Further to our recent exchange of messages regarding the above application, I attach revised floor plans drawing 519/18-08 Rev A with the footprint of the original property superimposed over, similarly attached is the proposed elevation drawing 519/18-09 Rev A with the profile outline of original property laid over.

I refer to the above application. The Parish Council have objected for the following reasons:

SIDE ELEVATION

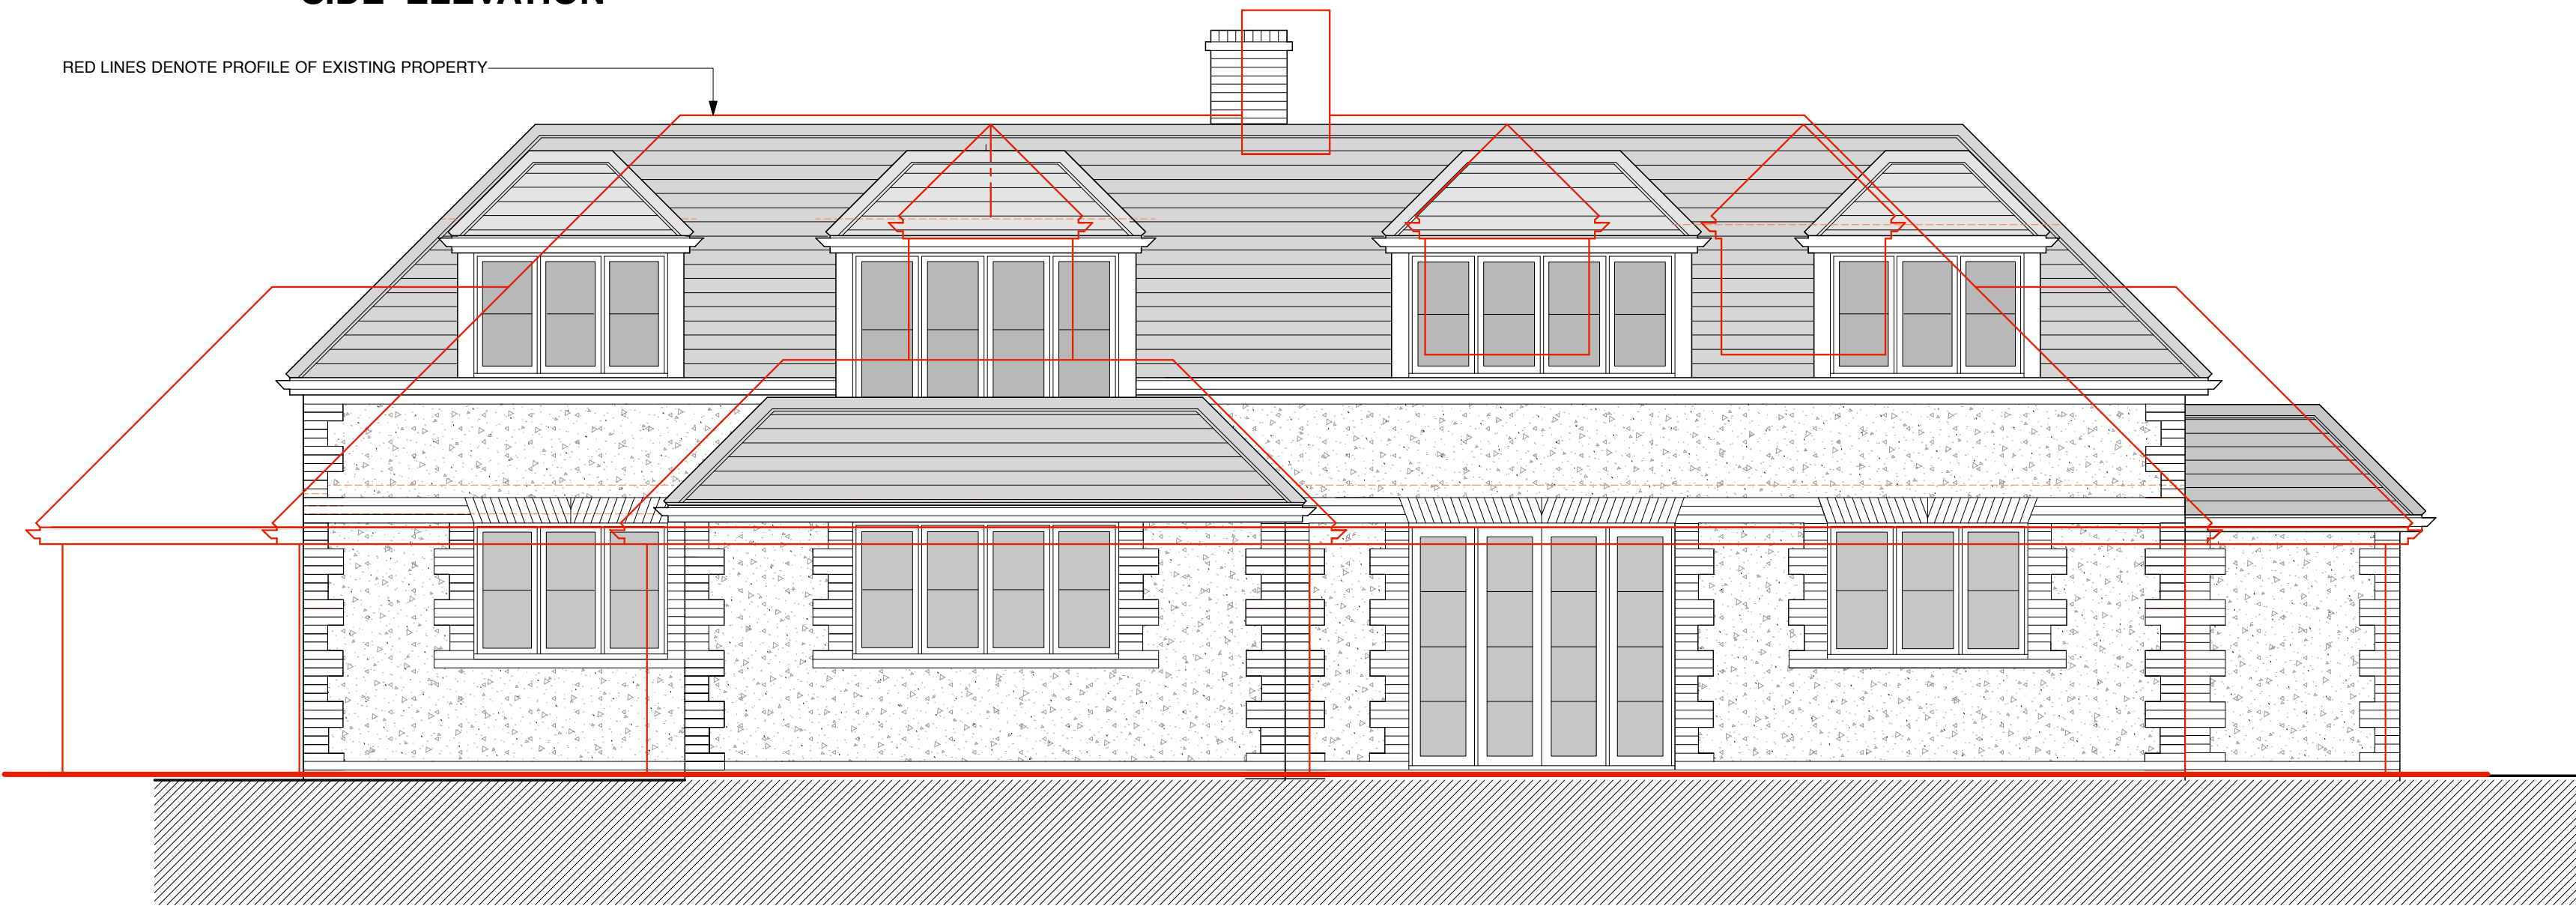
Further to our telephone conversation I have thought of another query. The materials are not referred to specifically on the submitted elevation plans and therefore won't be approved if the application drawings are approved. Since the dwelling is nearing completion it would be easier to the approve the materials with the plans rather than impose a condition. Accordingly can you arrange for the materials to be noted on the plans. I note that the tiles are as per the original dwelling, but have the elevation finishes altered? The form refers to 'natural finish' which should be clarified. You should provide details of the manufacturer of new materials together with the precise colour.

Previous concerns - Council repeats, for clarity, its previous concerns that the footprint and roof height of the new dwelling should match or are less than the demolished dwelling (roof height maximum 5.9 metres) and that materials to be used match those of the demolished dwelling.

Please can you provide comment and comparative footprint and elevations so that it is clear where any increase has occurred? I would appreciate receipt by the end of this week. As the application currently stands if it is recommended for approval the Parish Council objection will mean that the application will need to be determined by Development Control Committee and the March Committee agenda, which is the first available, closes at the end of this week.

Notes regarding the materials have been added to drawing 519/18-09 Rev A as referred to below.
